Planning Act 2008 - application for a Development Consent Order for Mallard Pass Solar Farm: Action from Issue Specific Hearing 4 – Environmental Matters (Day 1)

We note the Action to the Applicant and the Environment Agency resulting from Issue Specific Hearing 4:

‘Results of further liaison between the Applicant and the Environment Agency regarding flood risk implications of the operational time limit.’

DWG. NO. Appendix C

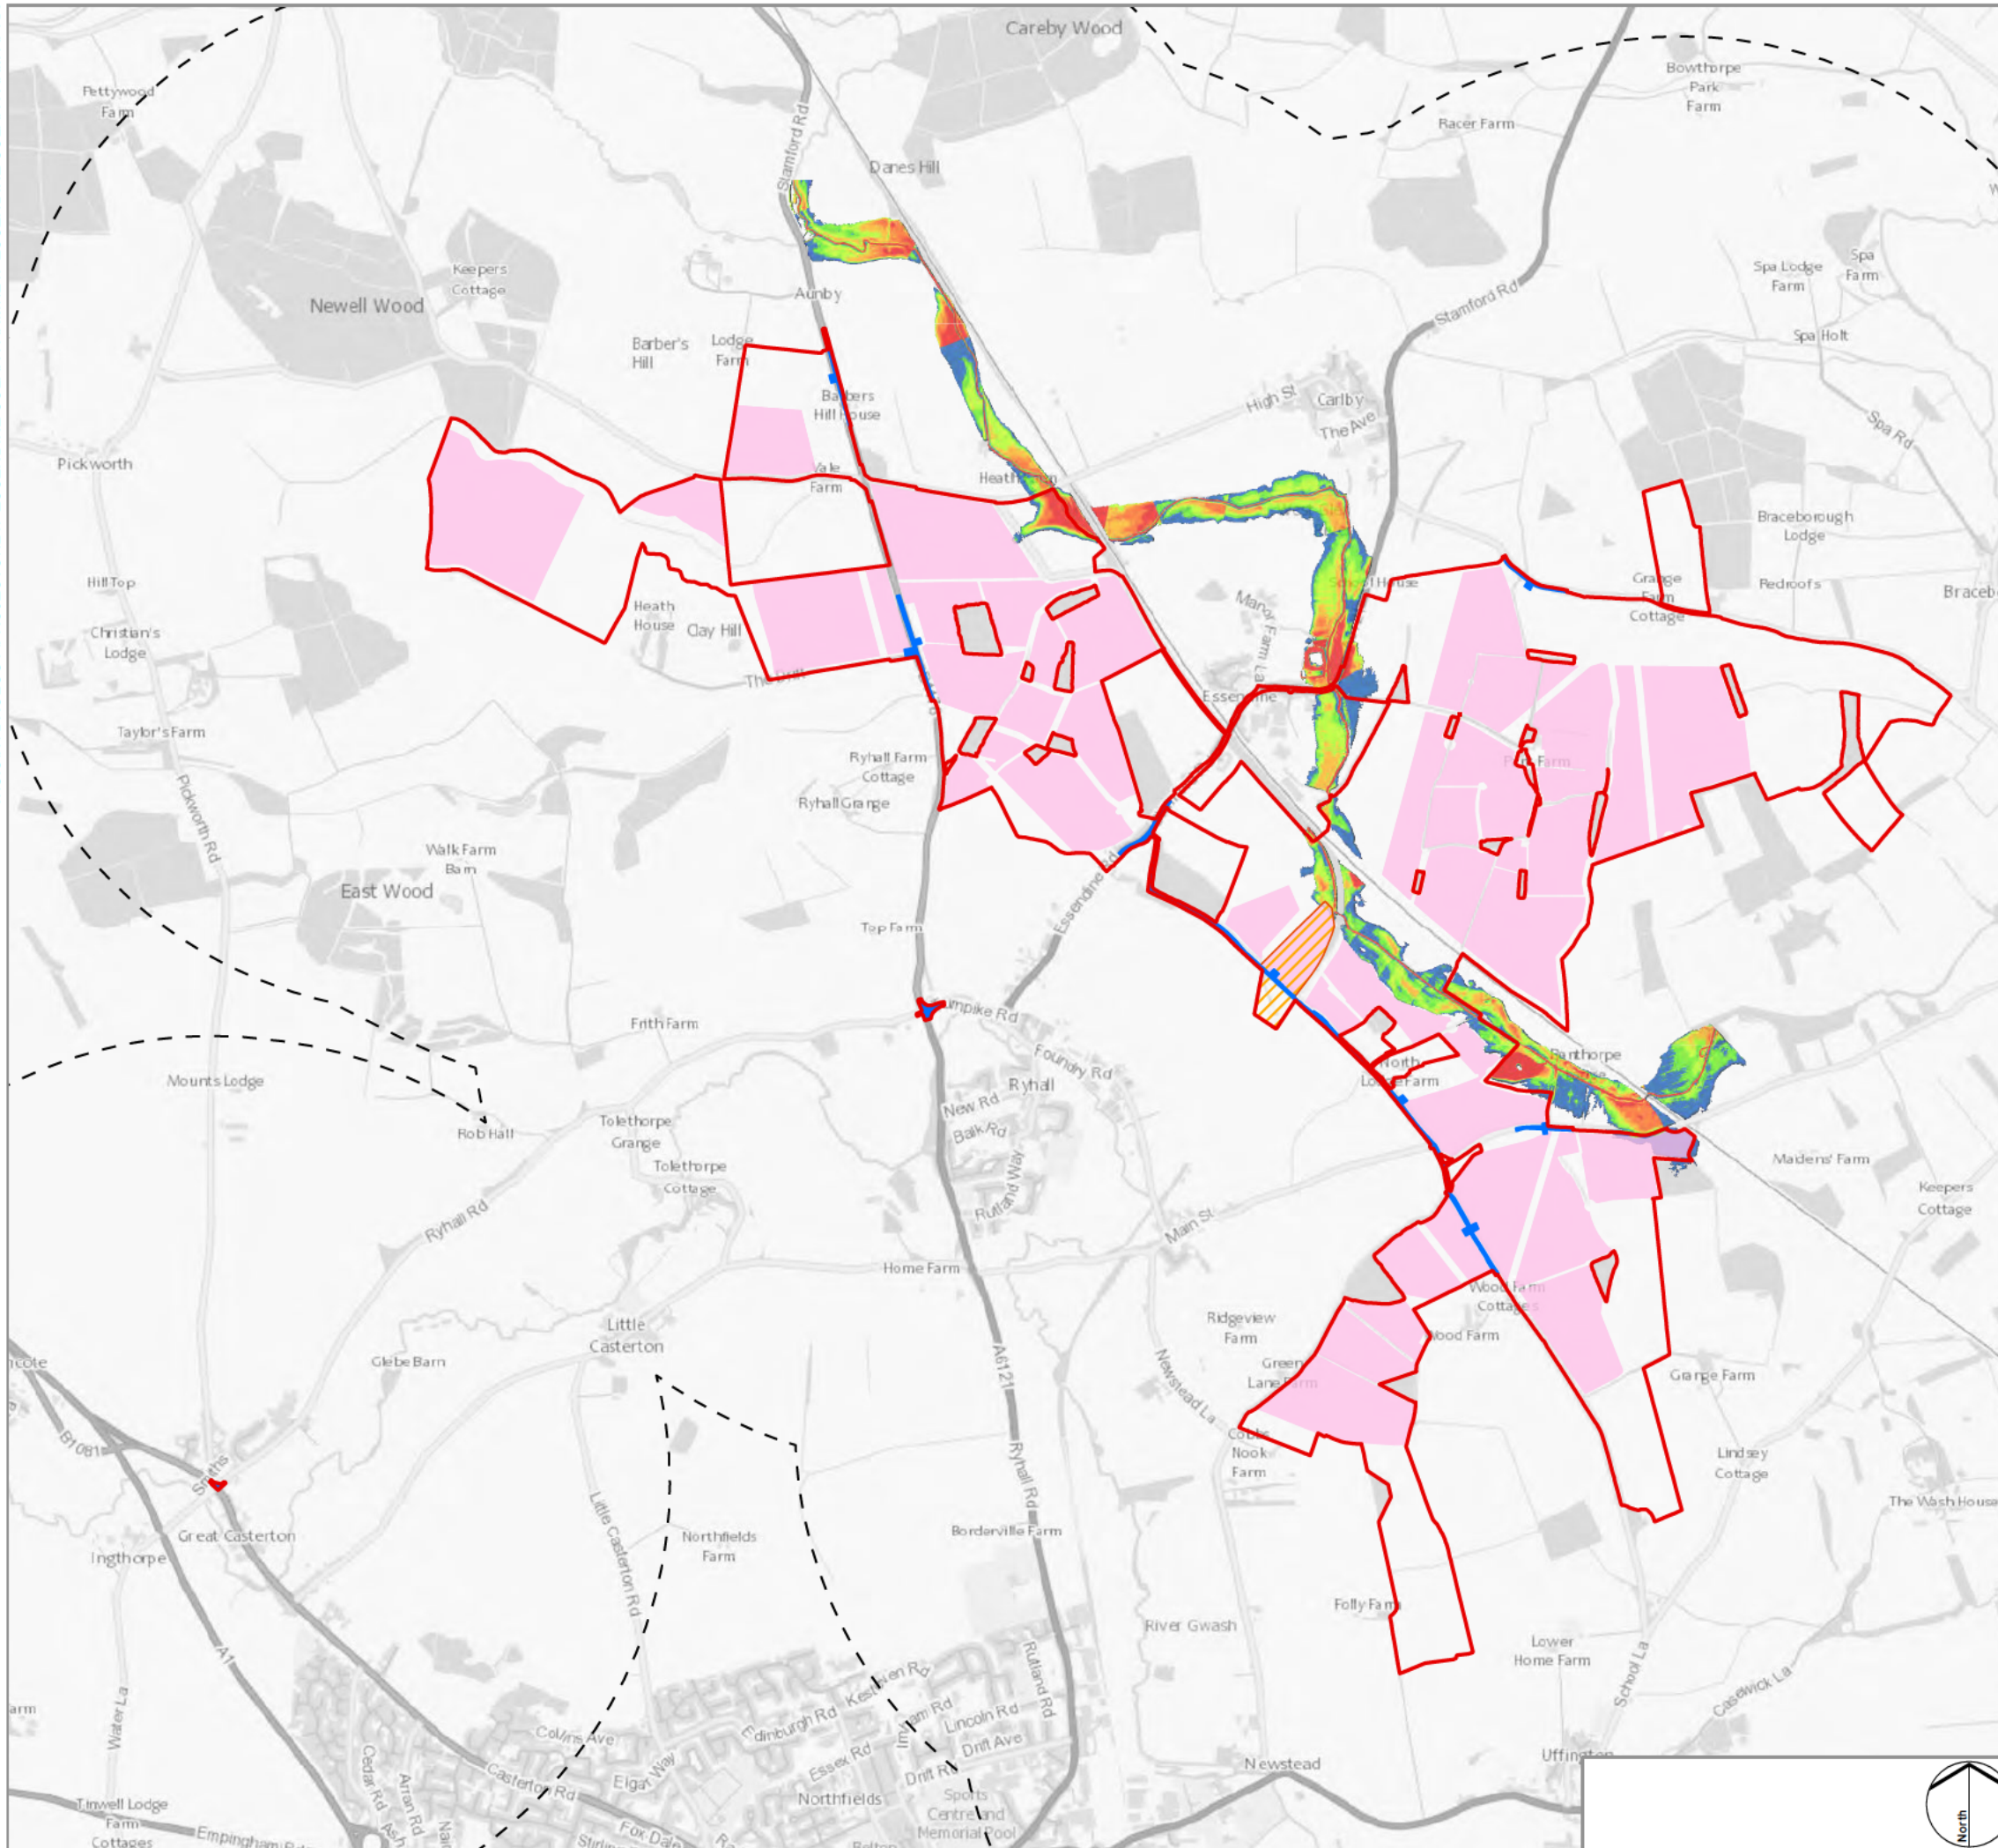
The current supporting flood risk assessment was based on modelling which included a climate change allowance of 20%; this is in excess of the allowance of 10% in the current guidance for the 2050s epoch. A potential decommissioning date of 60 years takes the development lifespan marginally into the 2080s epoch, which requires a 28% allowance in flows to be considered for the Welland Management Catchment.

We suggested to the Applicant that, as an alternative, they consider undertaking a rerun of the existing model to include the 28% scenario and design the site accordingly. We would not anticipate a significant difference between the 20% and the 28% scenarios.

The Applicant has now informed us that they have analysed and applied the 1:200-year (0.5% annual probability) flood levels to the existing ground profile, as a proxy for the 1:100-year (1% annual probability) event plus a 28% climate change uplift. They have stated their intention to submit this analysis at Deadline 7.

We are happy with this proposed approach and will review the submitted analysis and results when published. Should the results indicate that any additional mitigation or amendments are required to the layout of the solar farm, these can then be discussed and agreed and the draft Development Consent Order updated accordingly.
